Various tree surgery & felling.

Parklands & Poplars Estates Rustington

Thank you for your internet representation made on 31st October 2017 which has been recorded as '**an objection**' with the comments as follows:

BROOKEN BEE

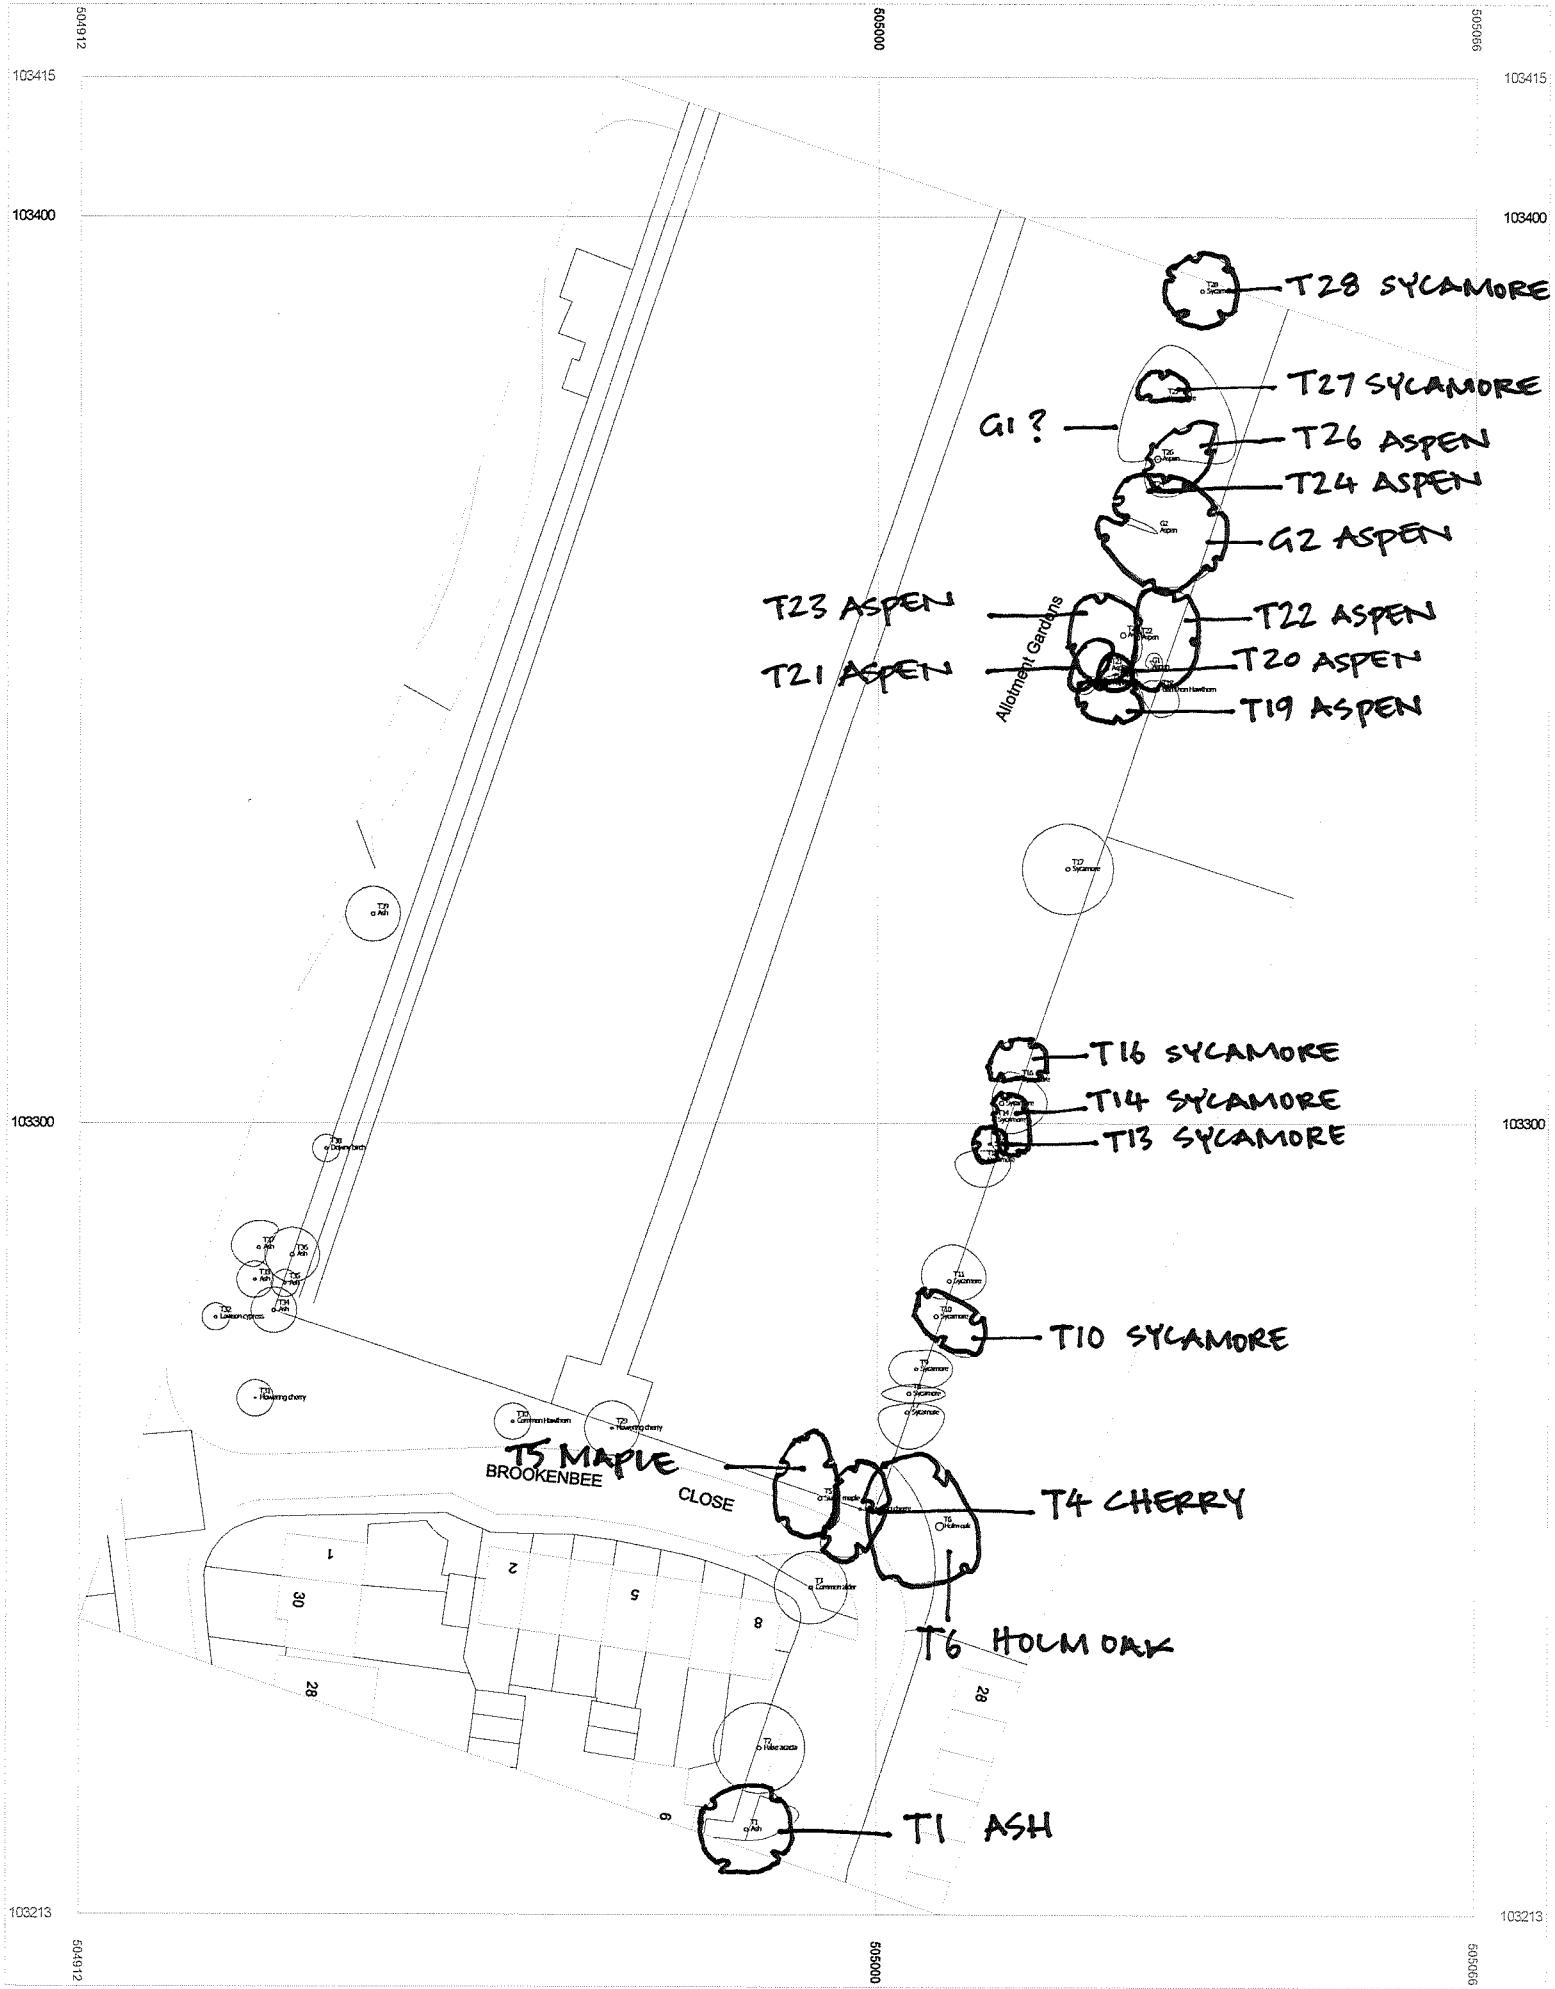
BROOKENBEE T18 Common Hawthorn, T39 Ash & G1 Aspen not located on plan. Works detail for T18 missing.

Re-inspection dates time expired for T6, T10, T20, T21, T23 & G1. Appropriate dates required. Re-inspection date for T39 missing.

PARKLAND HUTCHINSON SUMMERLY FOXES, - NORTH

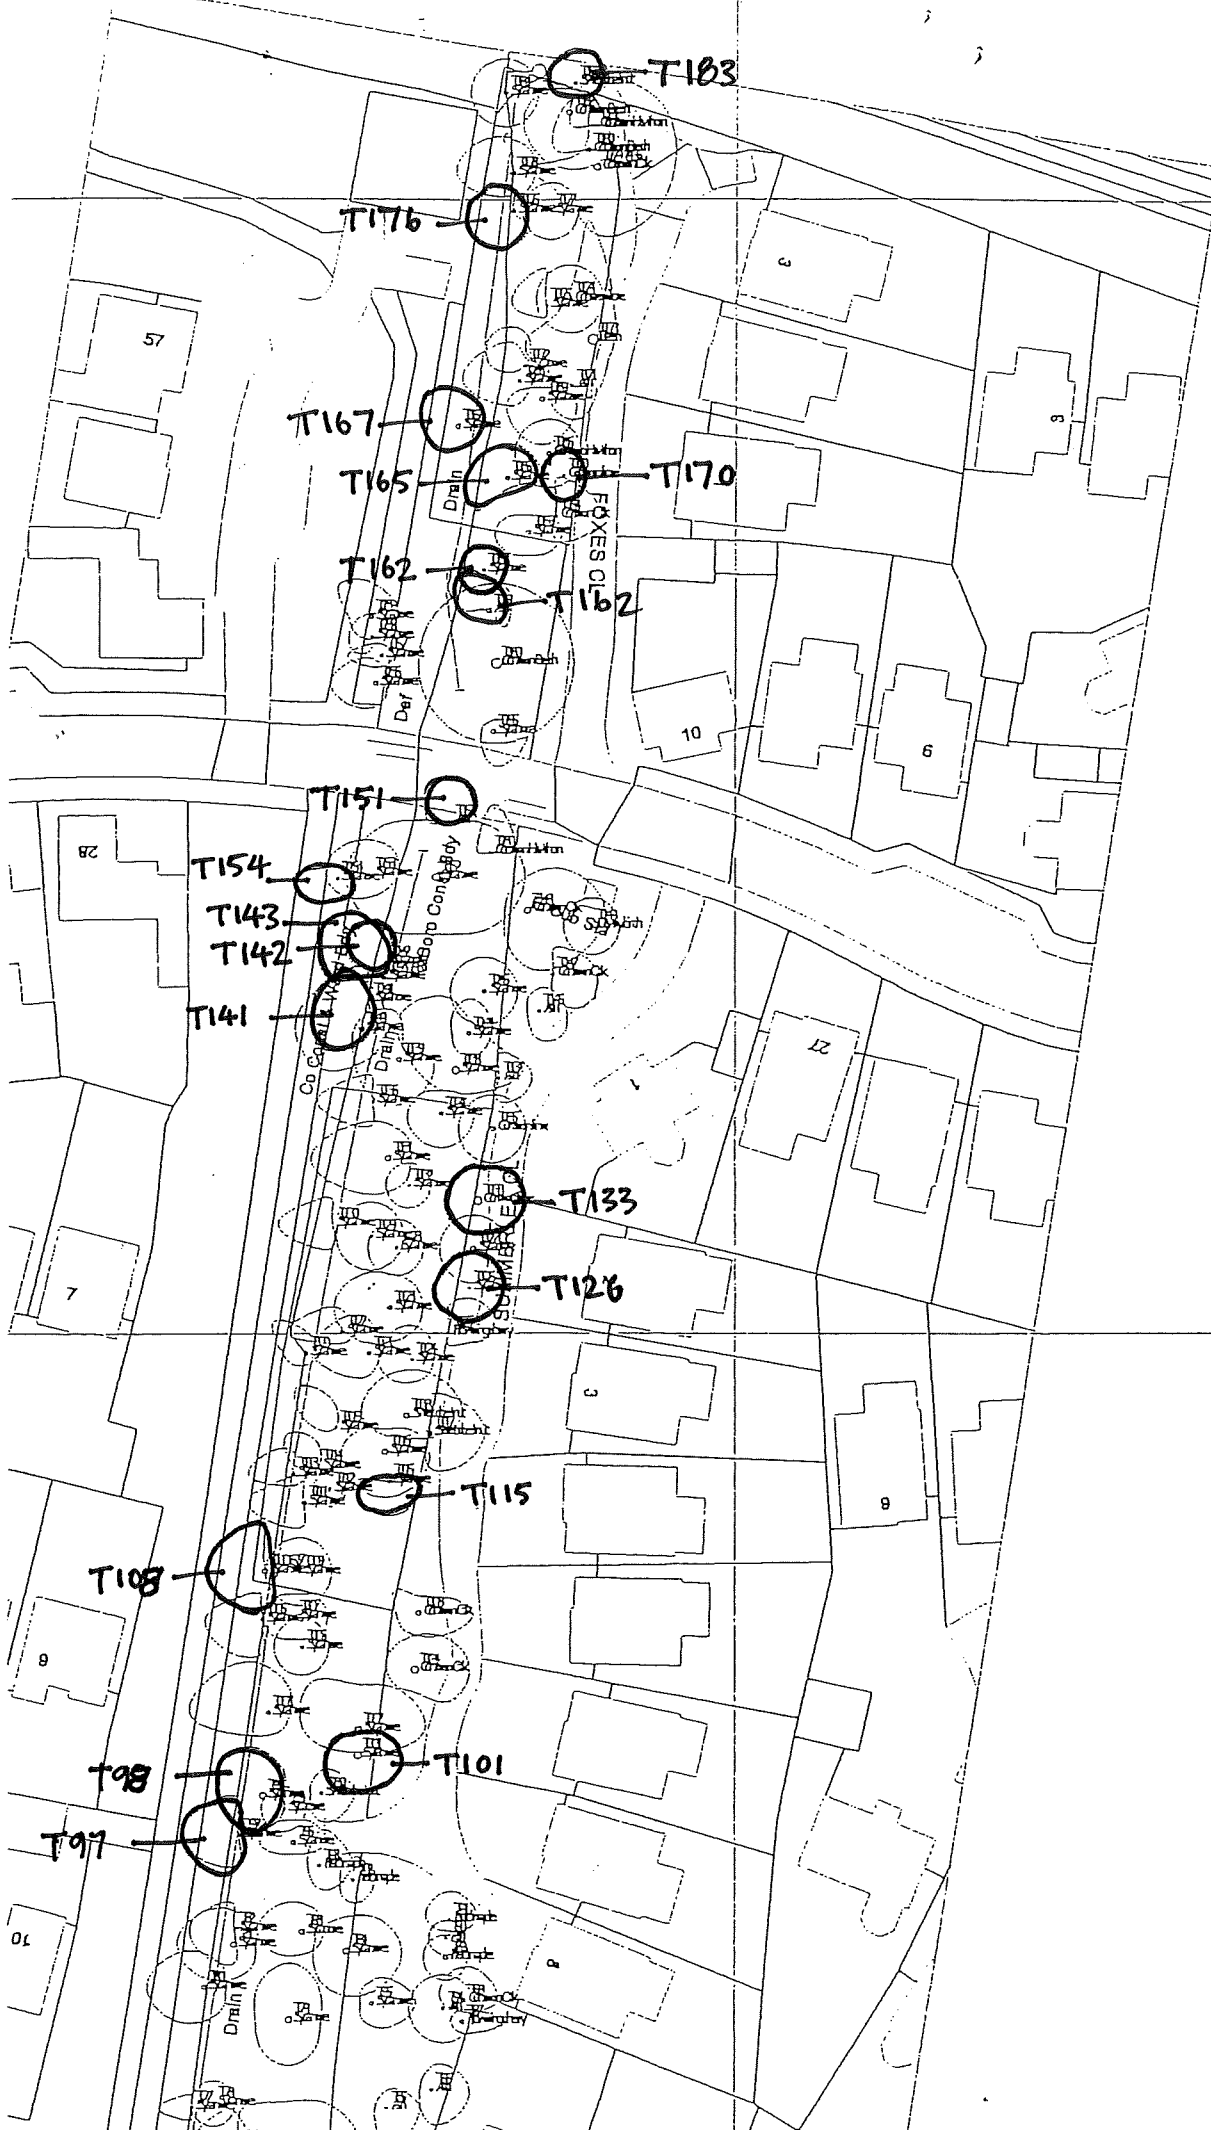
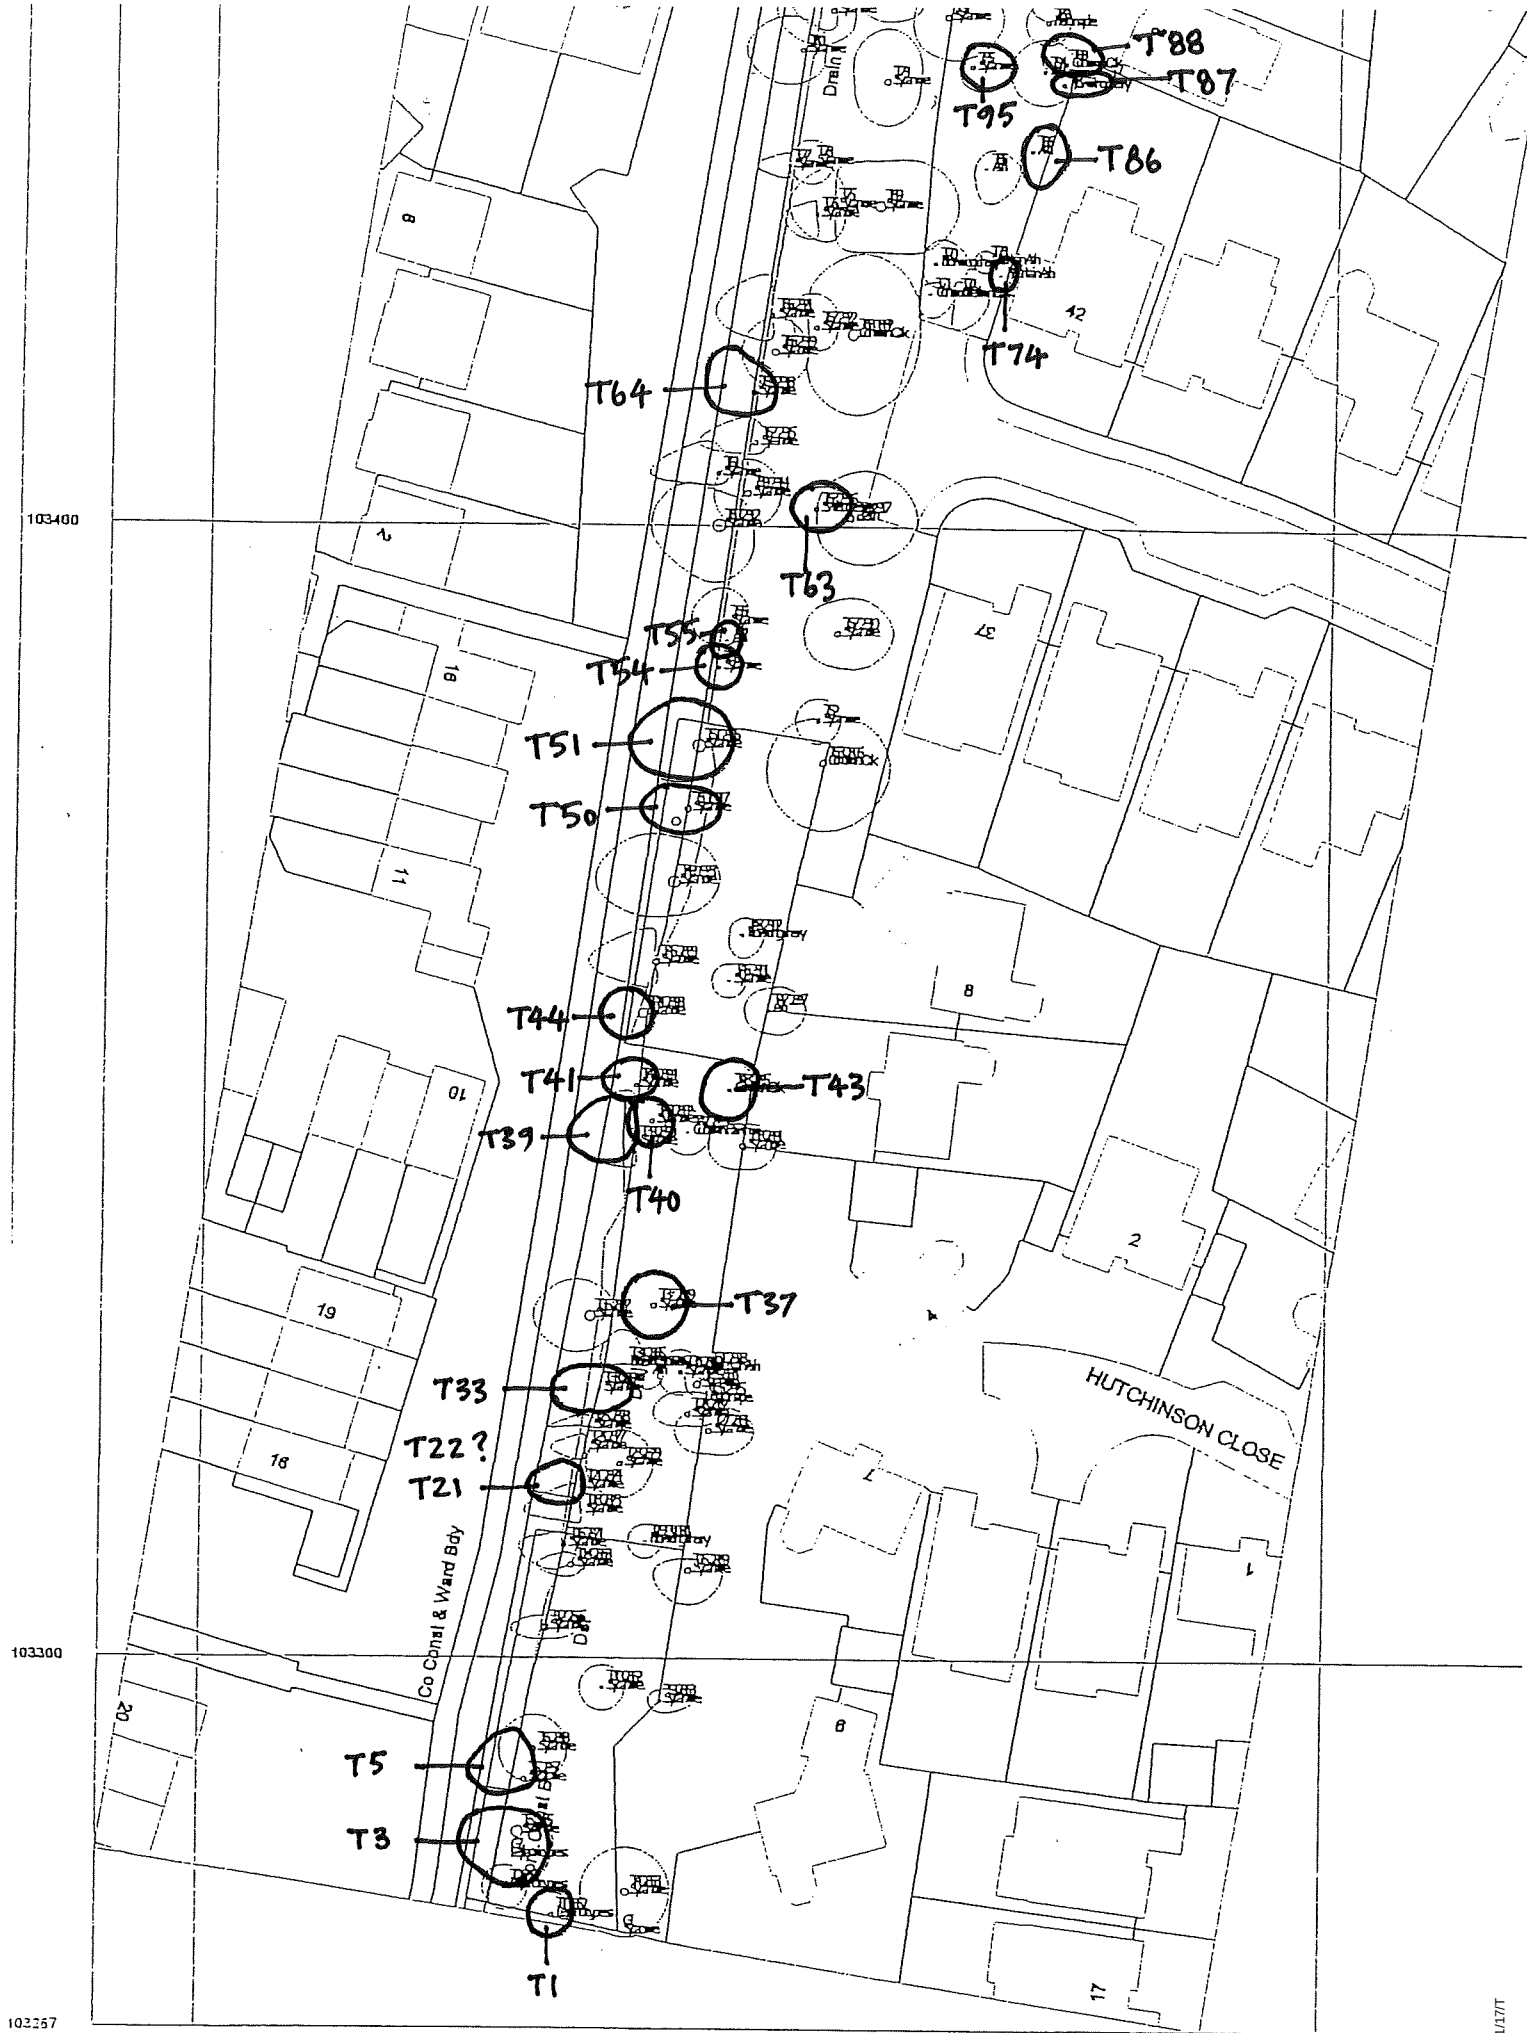
HUTCHINSON/SUMMERLY/FOXES Trees not located on

plan: T22, T45, T46, T49, T57, T59, T62, T65, T66, T67, T75, T79, T81, T83, T84, T103, T104, T113, T117, T121, T124, T130, T140, T155, T156, T158, T159, T160, T161, T166, T168, T169, T171, T172, T173, T174, T175, T177, T178, T179, T182 & T184.

T162 located twice. Re-inspection time, expired for

T3, T33, T39, T40, T41, T43, T44, T45, T46, T49, T50, T57, T59

T62, T64, T65, T66, T67, T75, T79, T81, T83, T101, T113, T126

T133, T140, T155, T158, T159, T166, T168, T169, T172, T173,

T175, T176, T177, T178 & T184. SAFETY INSPECTIONS HAVE

EXPIRED BY PERIODS OF UP TO 23 MONTHS.

PARKLANDS / COWDRAY DRIVE

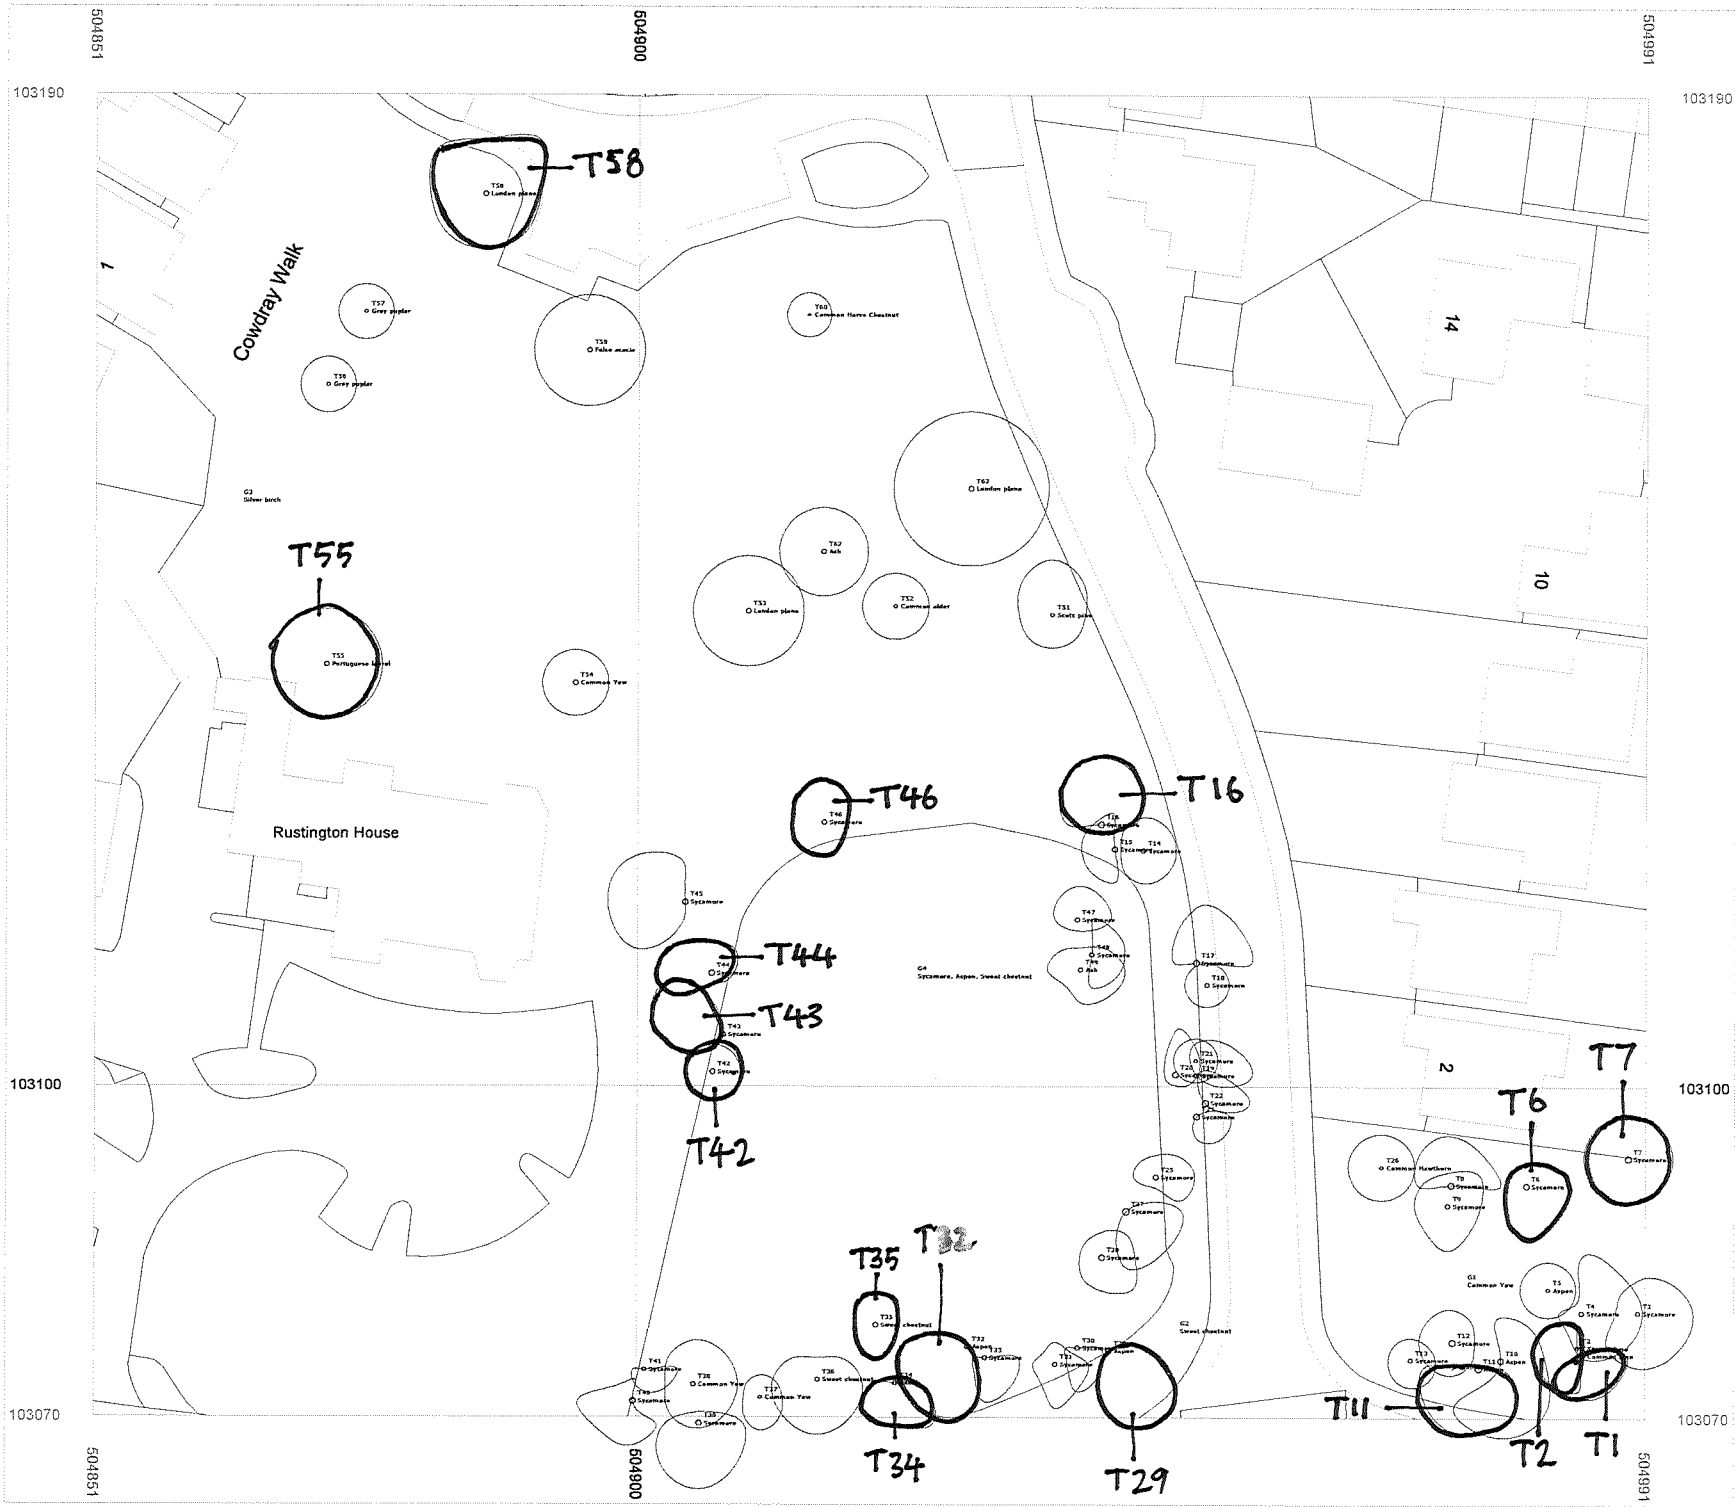
COWDRAY DRIVE T36 Sweet Chestnut & T39 Sycamore not located on plan.
